City of Albuquerque Stormwater Construction Site Inspection Report

General Information					
ESC File No.	G14E097		Project Name:		Calle Cuarta
NPDES Id. No.	NMR1005D6		Location:		3525 4th St NW
12/14/2023	Owner		Contractor		
Operator	Yes Housing, Inc.		Pavilion Construction		
Contact name & title	Page Ollice		Jared McCarn		
e-mail	pollice@yeshousing.org		jmccarn@pavilionconstruction.com		
Contact Phone #	505-923-9607		505-668-8854		
COA Inspector	Chancellor English		Start/End Time:		1015am
Construction Phase:	grading				
Type of Inspection:	Regular	Storm Event	Post Storm Event >0.25"	311/Complaint	Follow Up
Weather at time of inspection?		Rain		Temperature: ~ 45	
Estimated date of last storm 0.25" or greater		12/14/2023

YES CALLE CUARTA TH, LLC
CALLE CUARTA RESIDENTIAL
SUBDIVISION
TESCP - PWO

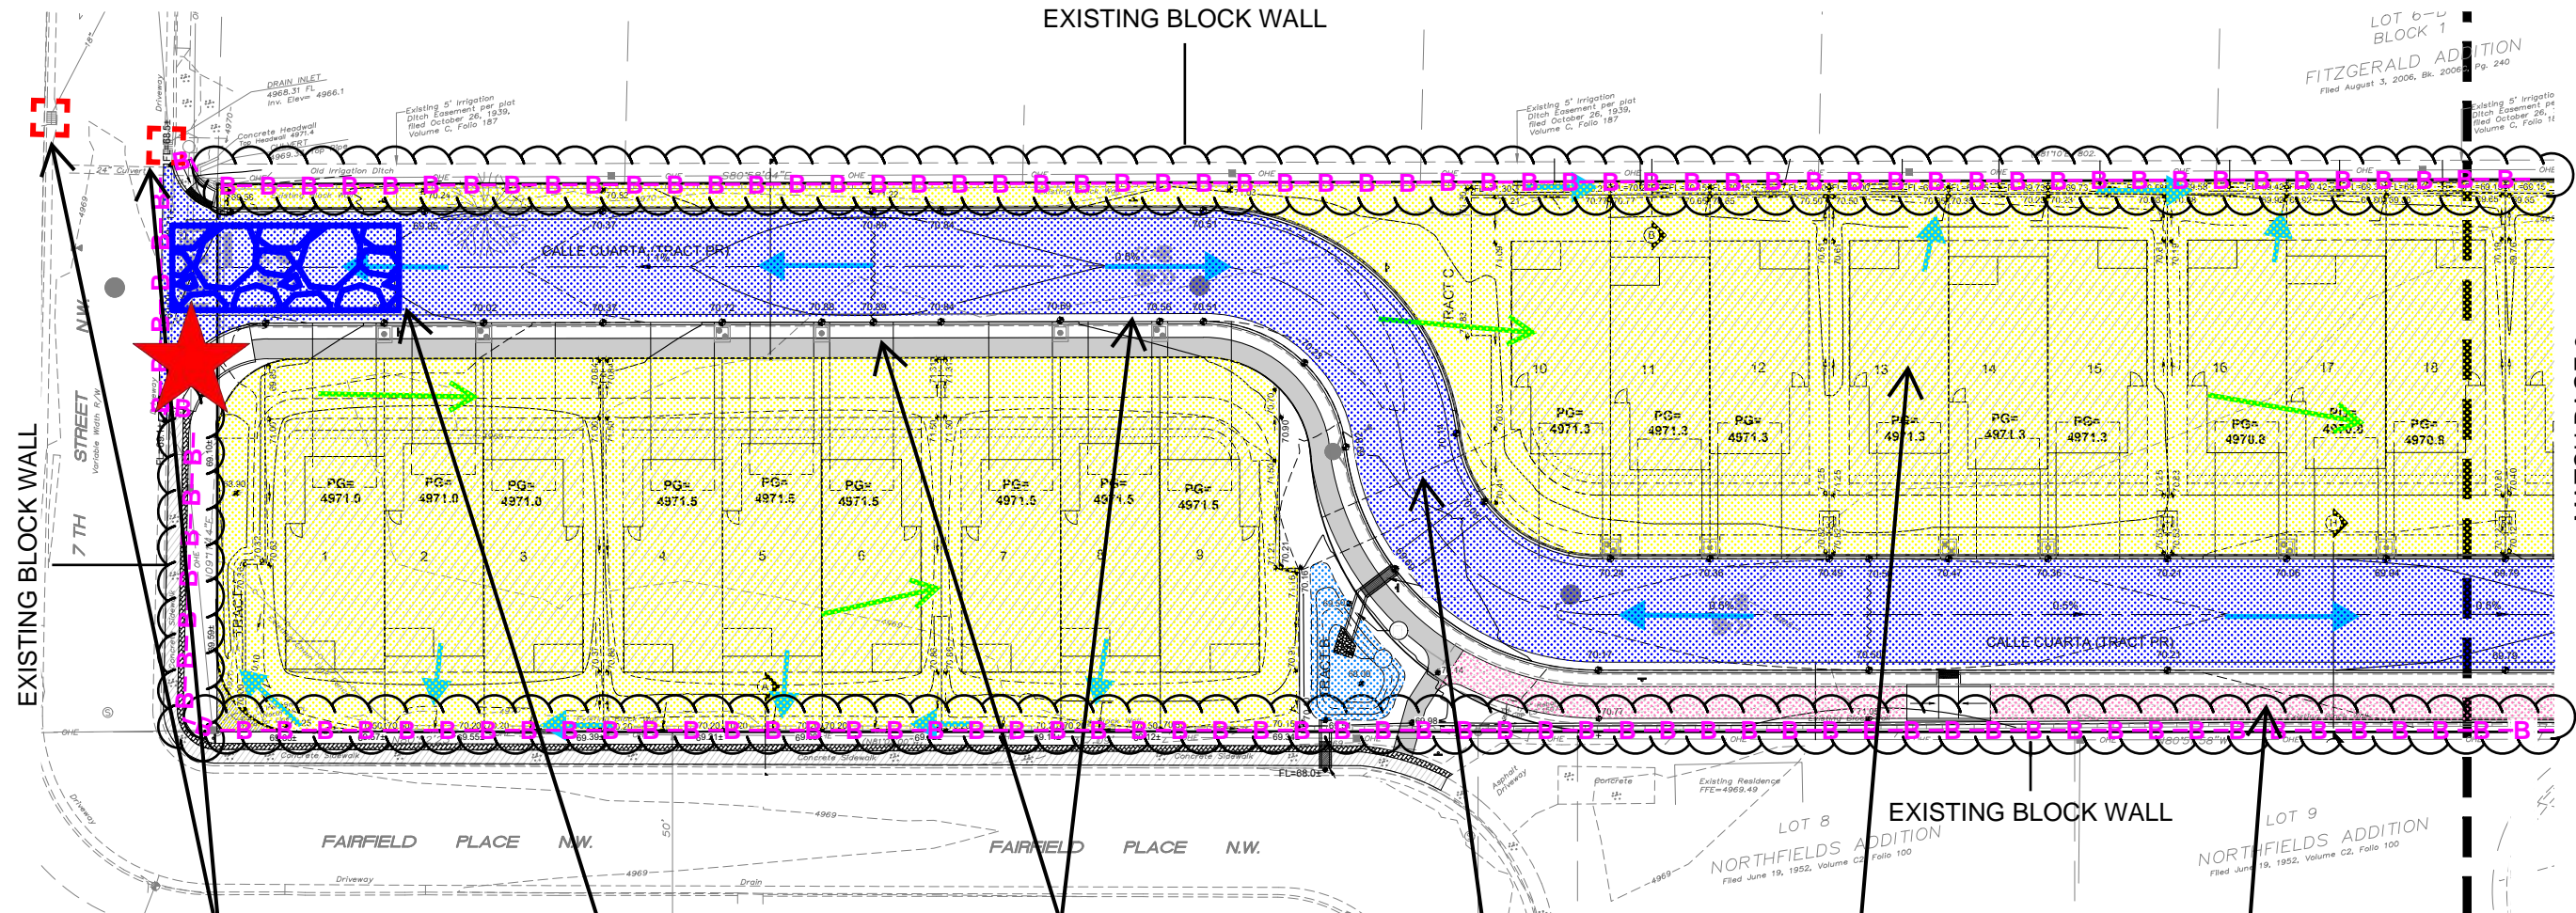
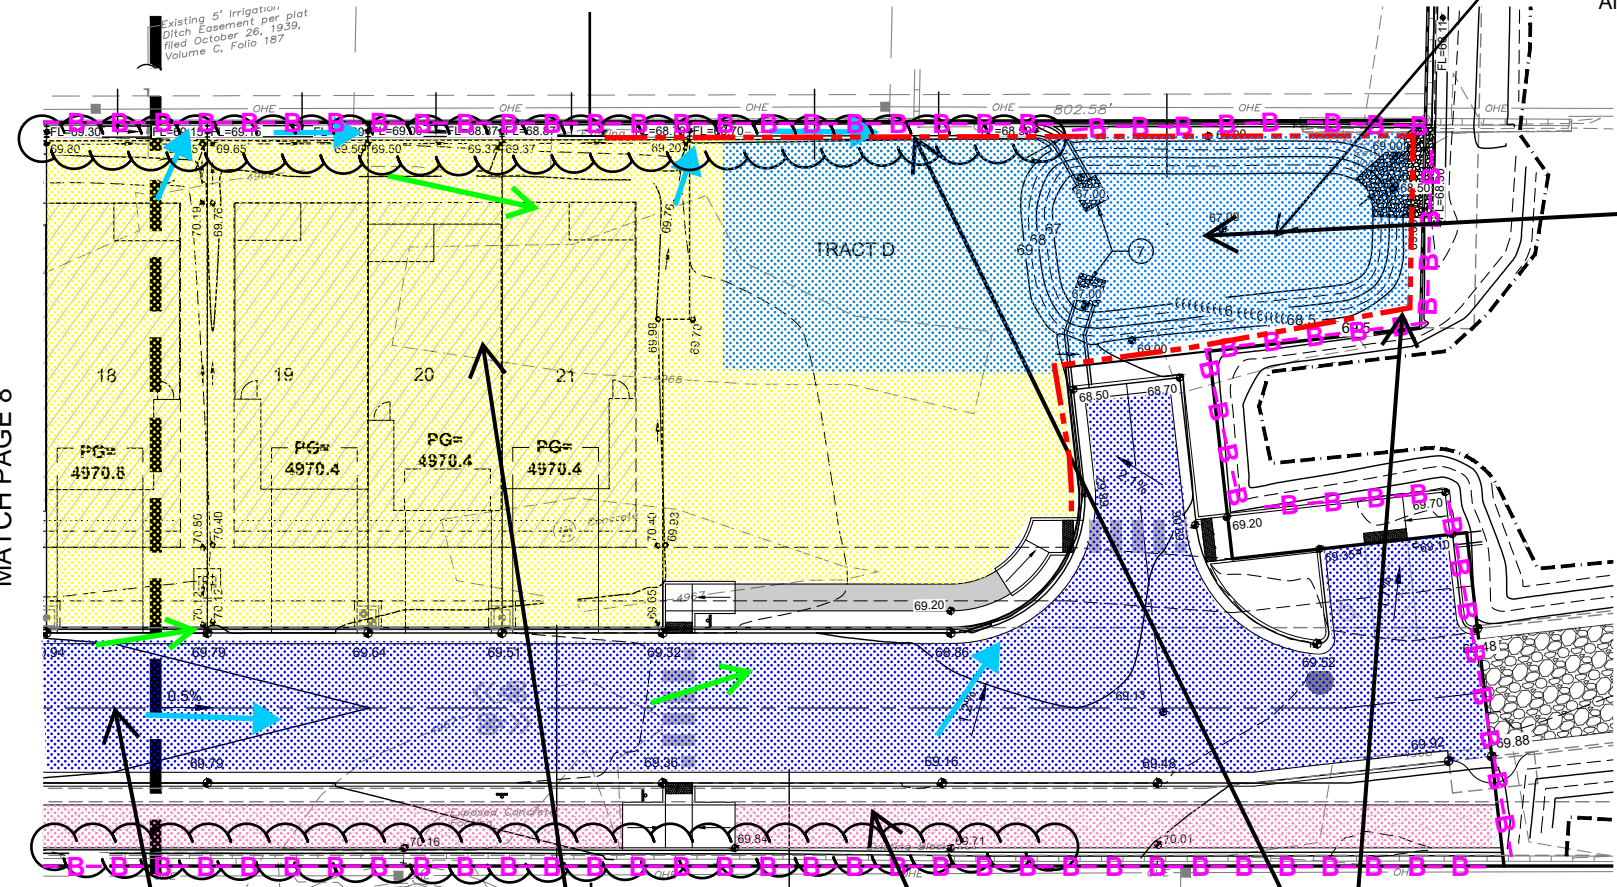
Item Number	Deficiency/ Corrective Action				
1	BMPs - The silt fence along Fitzgerald Rd. is still not entrenched in violation of CGP Part 2.1.2. There are no perimeter stormwater controls along the neighboring property (504 Fitzgerald Rd.) in violation of CGP Part 2.2.3. Required Mitigation: You must install all stormwater controls in accordance with good engineering practices, including applicable design specifications per CGP 2.1.2. Silt fencing requires entrenching in order to be an effective stormwater control. Install sediment controls along any perimeter areas of the site that are downslope from any exposed soil or other disturbed areas per CGP Part 2.2.3. The elevated pads that have been installed mean the perimeter is downslope of the disturbed soil.				
2	SWPPP - The self-inspection reports were unavailable at the time of the inspection in violation of CGP Part 4.7.3 and City Ordinance § 14-5-2-11. The SWPPP Map needs to be updated to reflect the current on-site conditions regarding the construction fenced area on the neighboring property in violation of CGP Part 7.4.1. Required Mitigation: At a minimum, a routine compliance self-inspection once every 14 days and after any precipitation event of ¼ inch or greater until the site construction has been completed and the site has been determined as stabilized by the City per City Ordinance § 14-5-2-11 and CGP Part 4.2. You must keep a copy of all inspection reports at the site or at an easily accessible location, so that it can be made immediately available at the time of an on-site inspection per CGP Part 4.7.3. You must modify your SWPPP, including the site maps, within seven days you make changes to your construction plans, stormwater controls, or other activities at your site that are no longer accurately reflected in your SWPPP per CGP Part 7.4.1. Amend the site map to reflect the current boundaries of the construction site.
